# PUDSP19005-R3-LOI-Redlines Summary\_Markup Summary

# PUDSP19005-R3-PUDSP-Redlines Summary\_Markup Summary

SITE SPECIFIC NOTES:

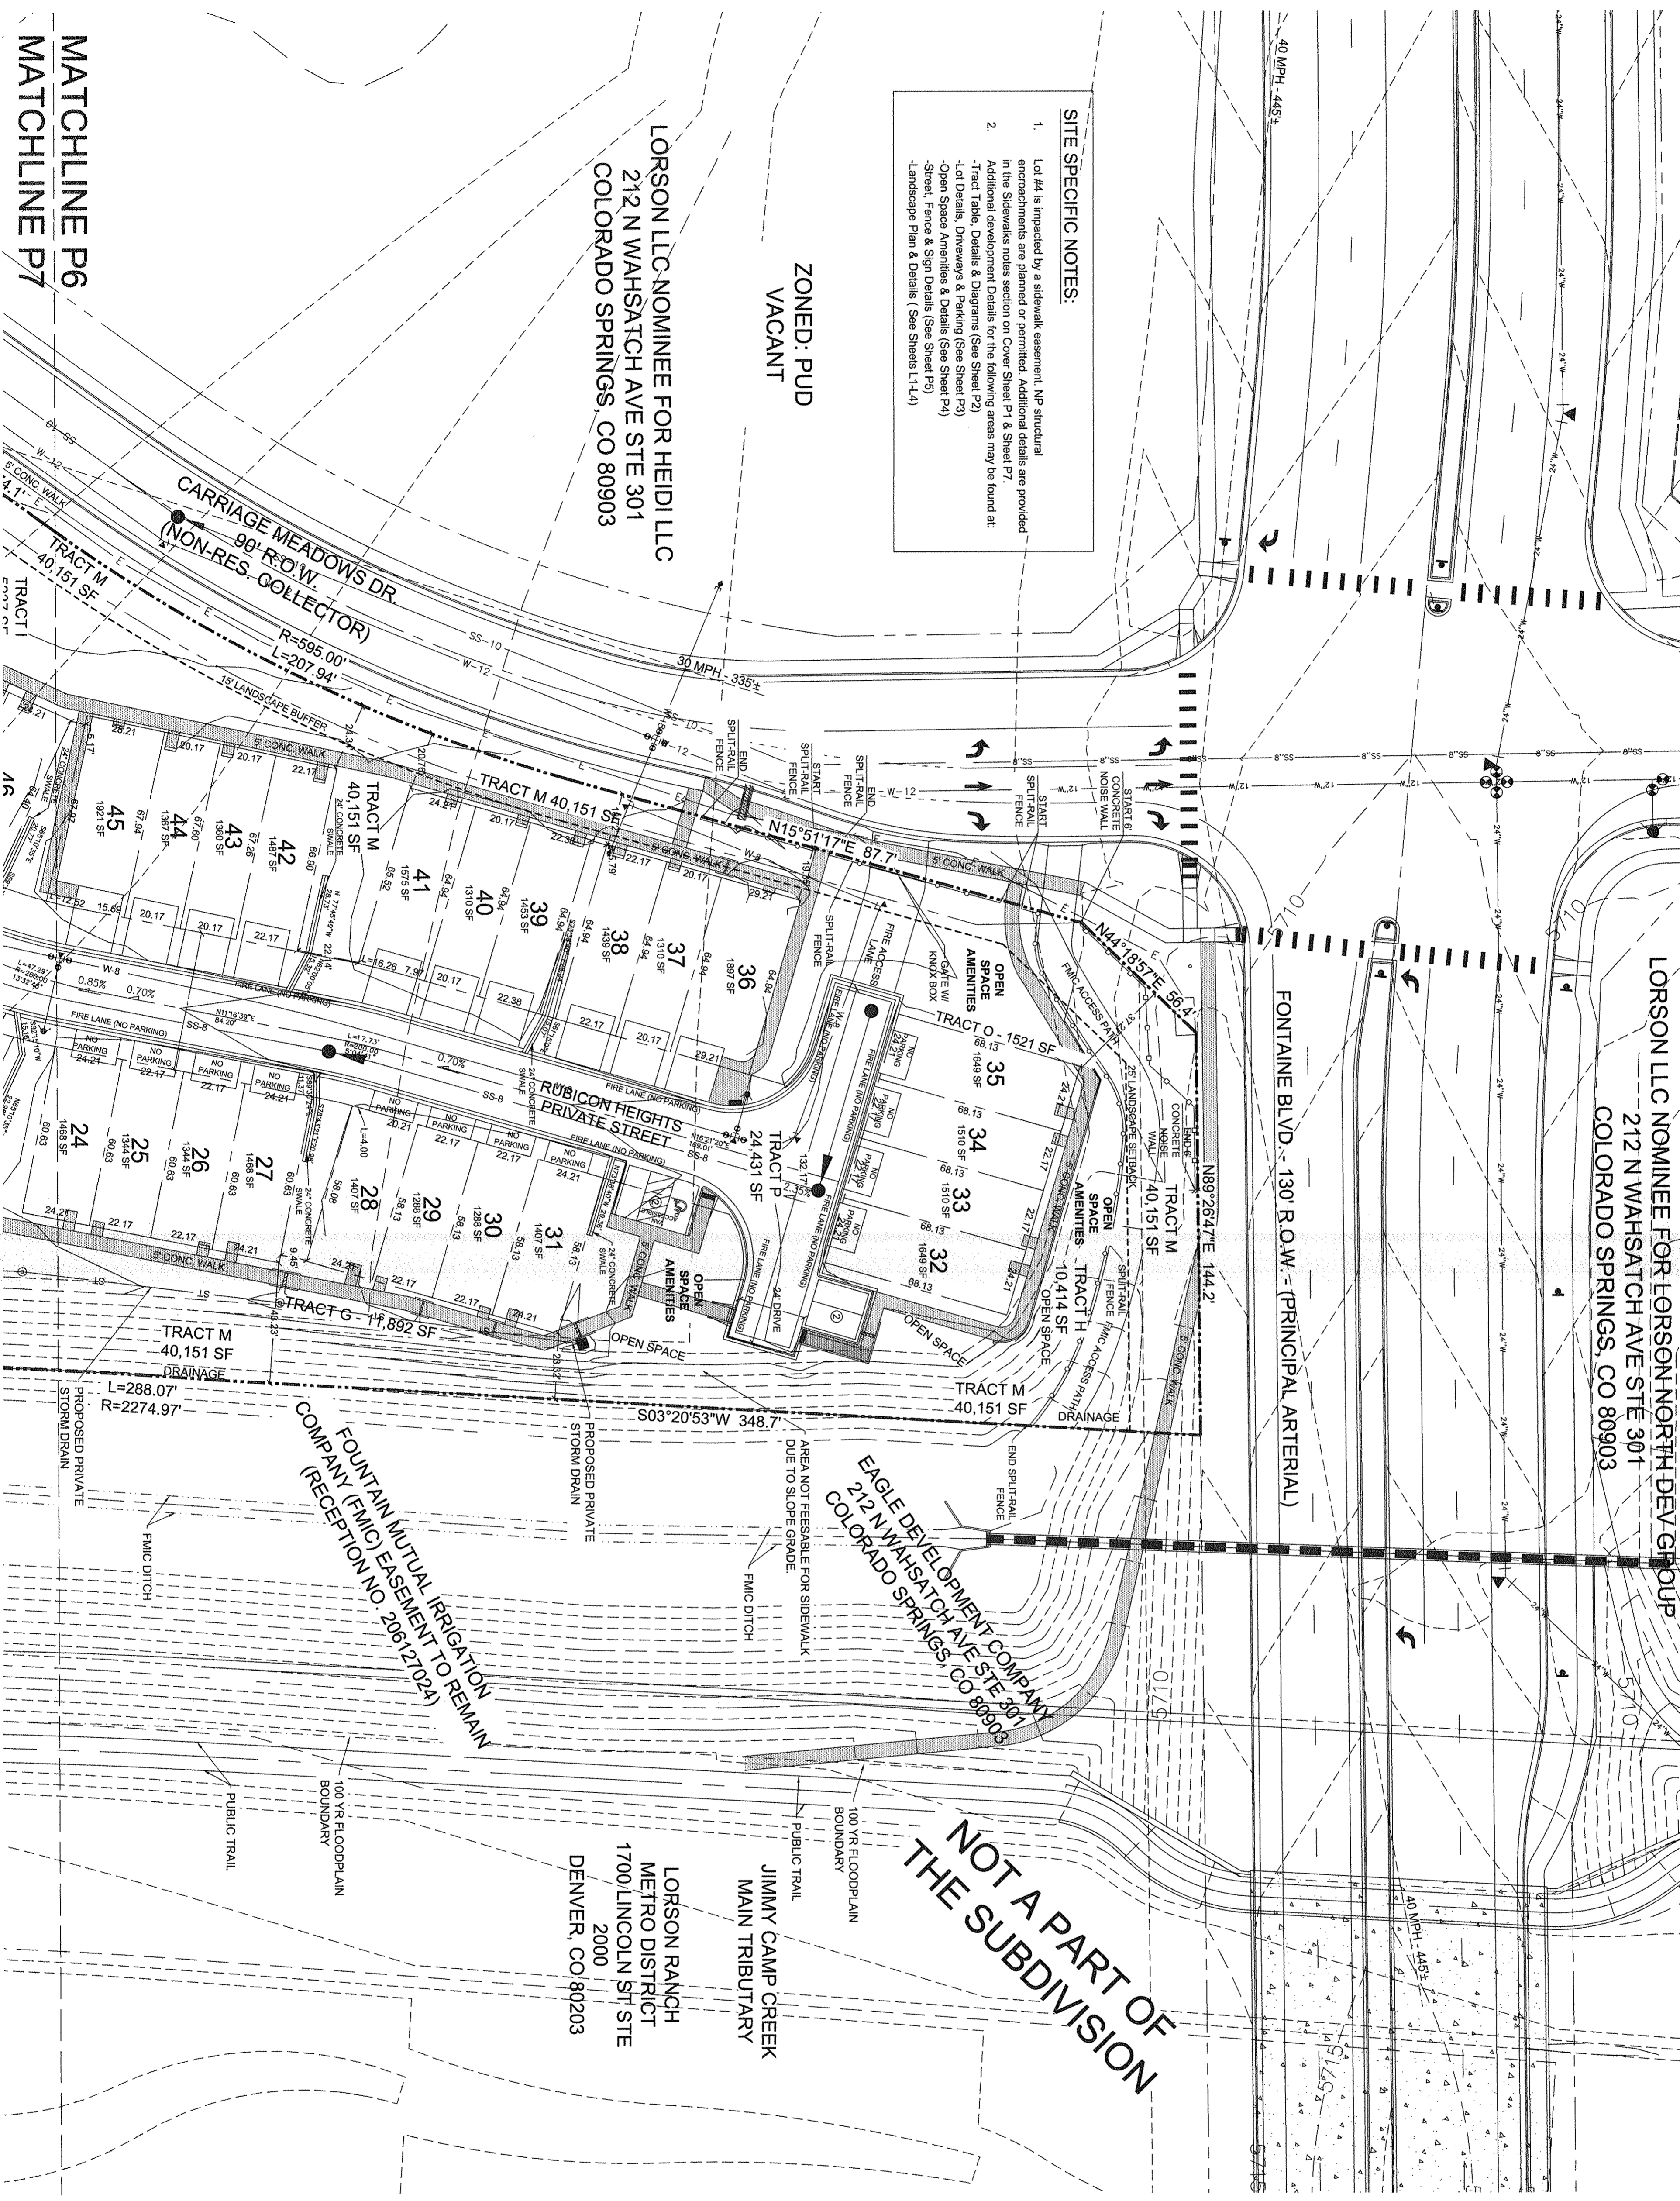
pick up the missing ADA spot here

increase all texts that is this small throughout- it will not be legible on recorded PUD Maybe 10 font-

you can provide a note or hatch with key that identifies all the lots that allow parking, and that do not if you prefer

label the tracts as parks or drainage or both; identify SF
